From: Stephen Gee [REDACTED]
Sent: 04 February 2021 11:34
To: James Cross <James.Cross@arun.gov.uk>; Kerry Simmons [REDACTED]
Cc: Planning.Responses <Planning.Responses@arun.gov.uk>
Subject: RE: BN/135/20/PL - Boweries

1. **Speed survey or amended visibility splays.** Please see the attached with amended visibility splay. - Accepted
2. **Further Information on pedestrian and cycle linkages:** Points 2,3 and 4 are broadly similar, but the linkages should be shown on the site plan. – These are not identified on the site plan and should be done so. – what

scale	1:200 @ A3	drawn by	RB	checked by	AP
date	MARCH 2021	cad file	MBSK210326.DWG		
drawing number	MBSK210326/02			rev.	-

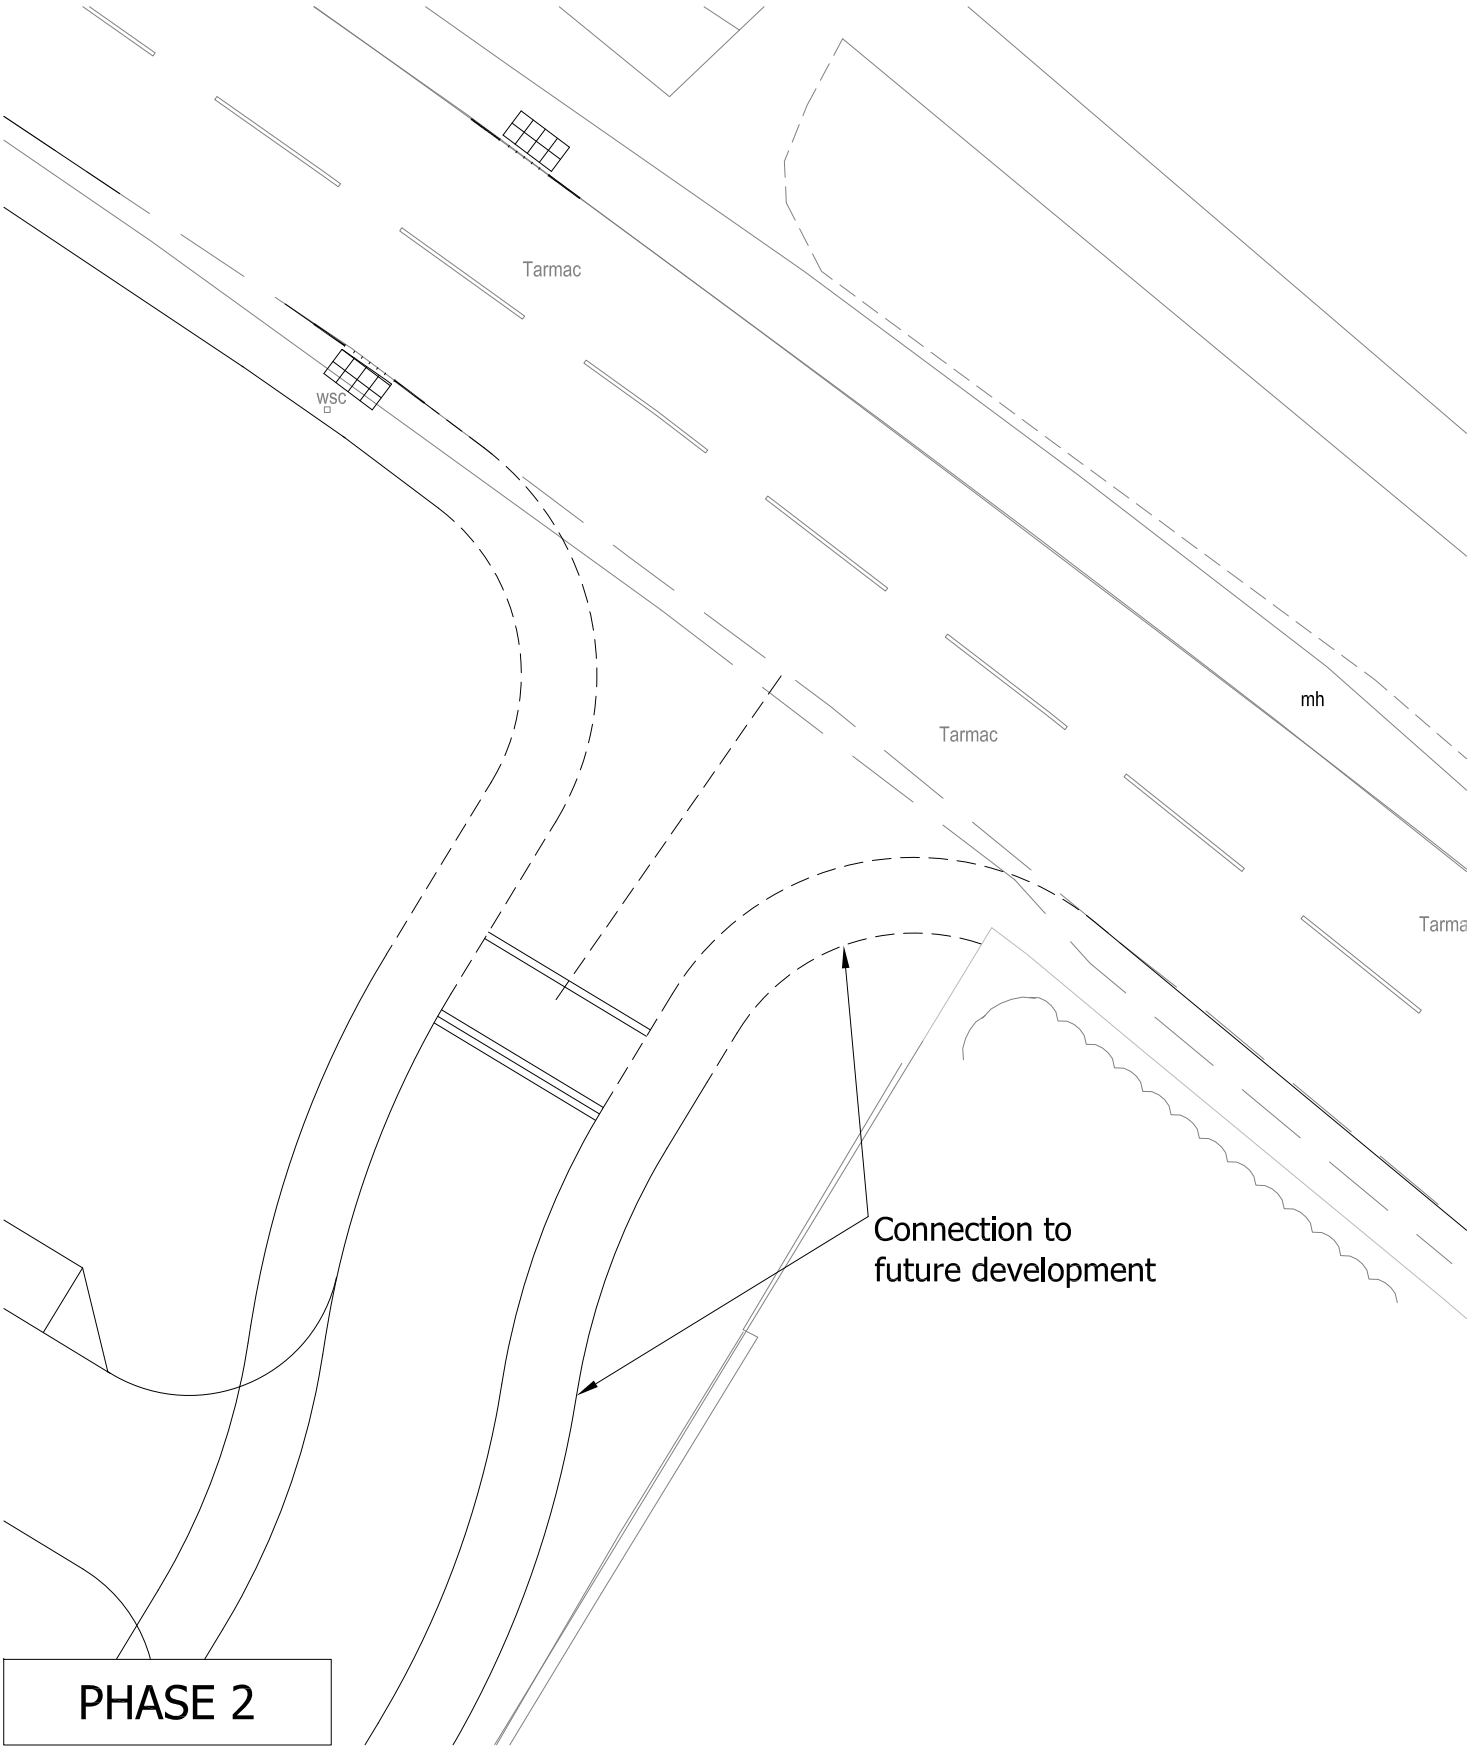
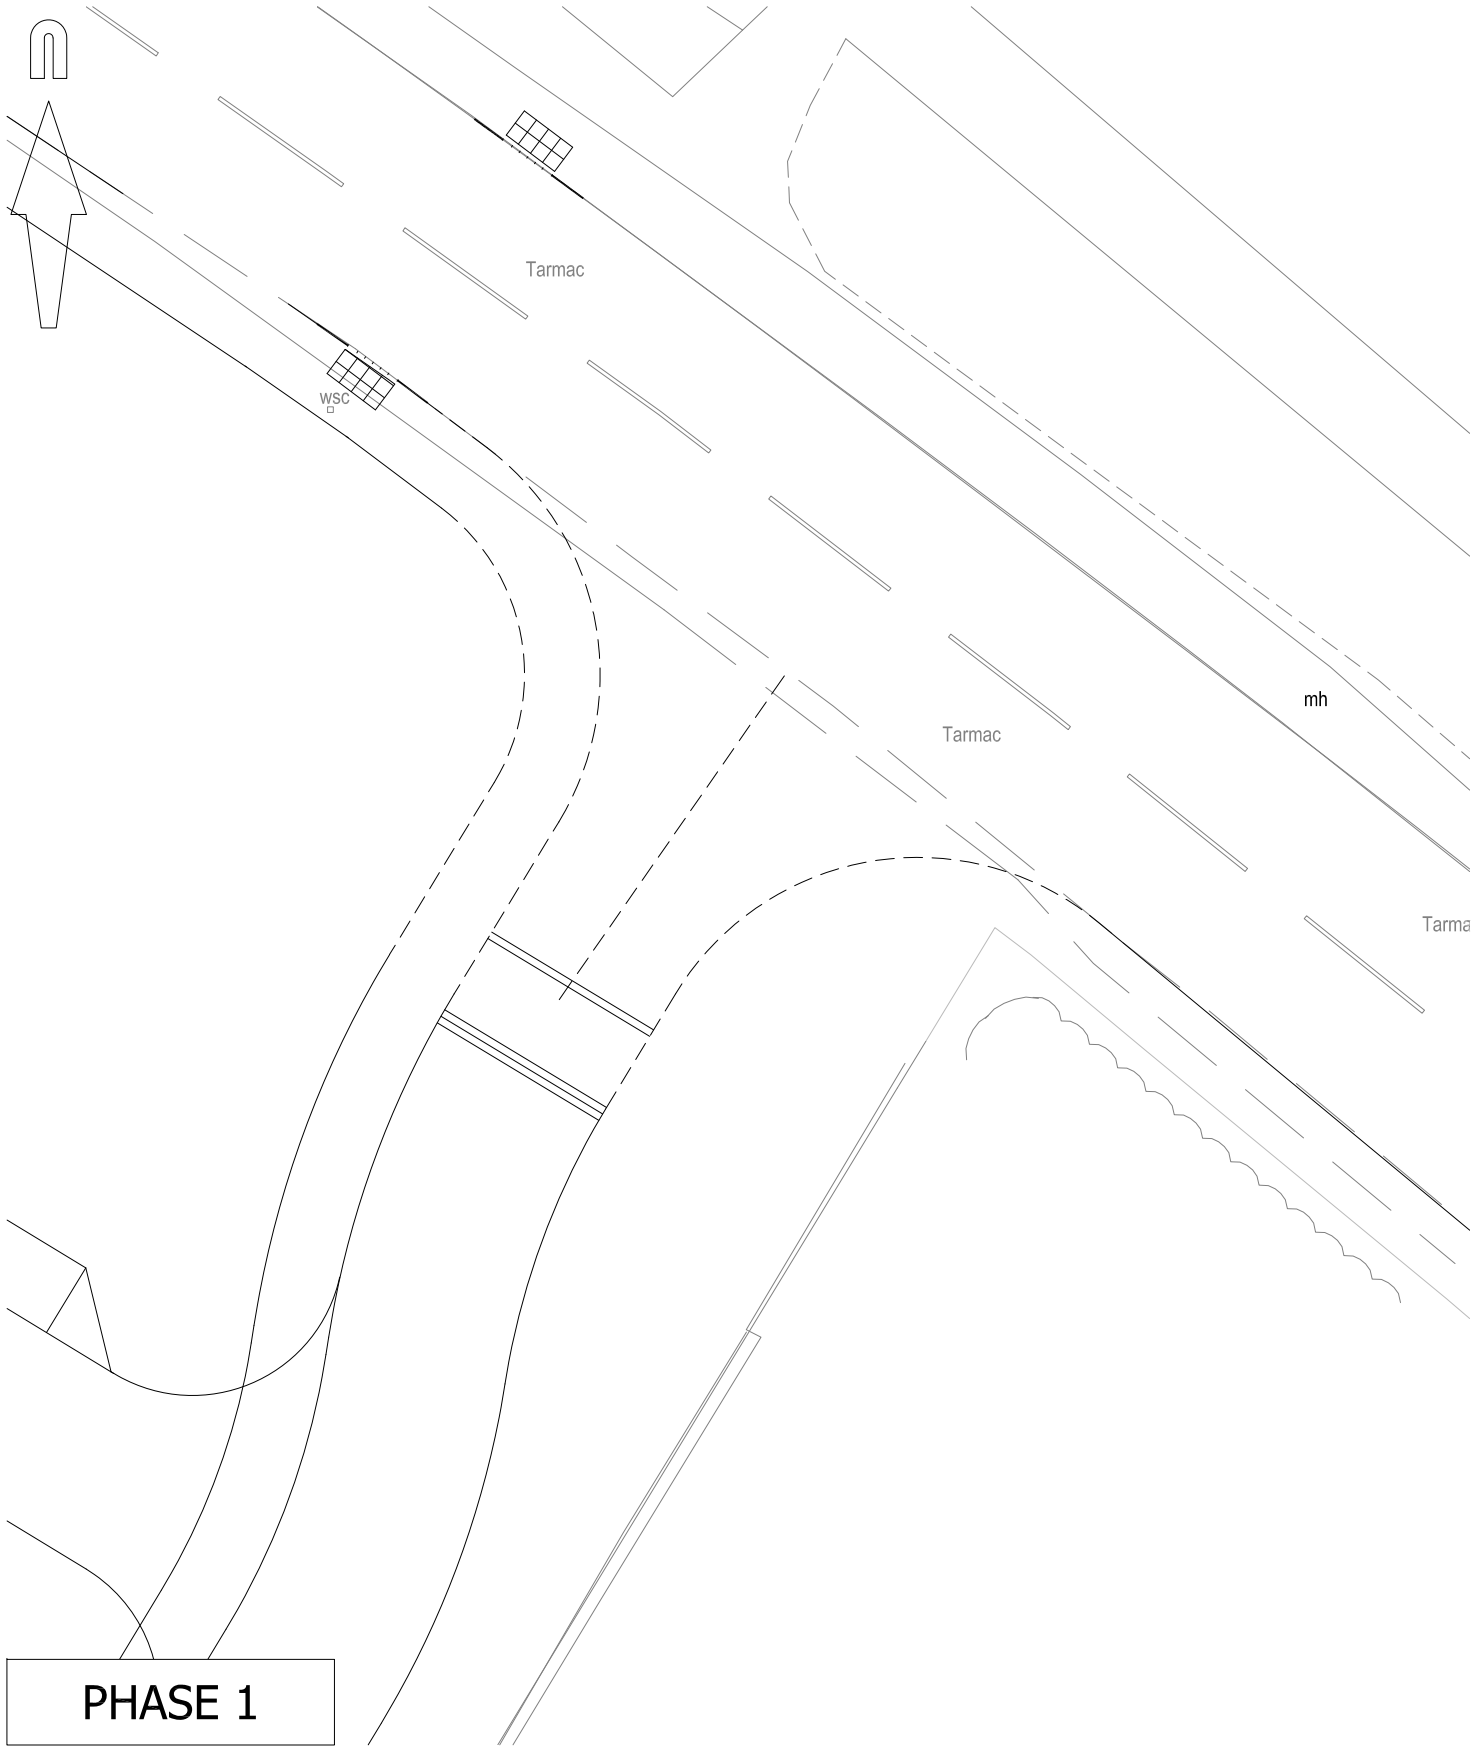
provision is made for cyclists/peds to cross the road when emerging from the green corridor? The parking plan shows an internal connection to the site to the east close to the access but is not shown on the access plan and its implications concerned. Link to the south shown and acceptable

3. **Details of what would be constructed prior to adjoining sites coming forward:** We would construct everything shown within our control including the 'green corridor', and tactile paving, dropped kerbs and pavement would be provided on Barnham Road. The eastbound ped interaction at the site access may need to be looked at if the adjoining site does not come forward in a timely manner. The footway along the easternside of the north south spine may encourage peds to cross Barnham Road east of the site access on the desire line rather than crossing twice (site access and then Barnham Road).

Provision of stage 1 RSA and GG119 appendix F Designers response: Please see attached. The access has changed since the RSA and vehicle tracking shows over run. Given this is one of the issues raised by this should be reassessed. Also Please note this is not a GG119 appendix F Designers response compliant response, the correct template can be found here
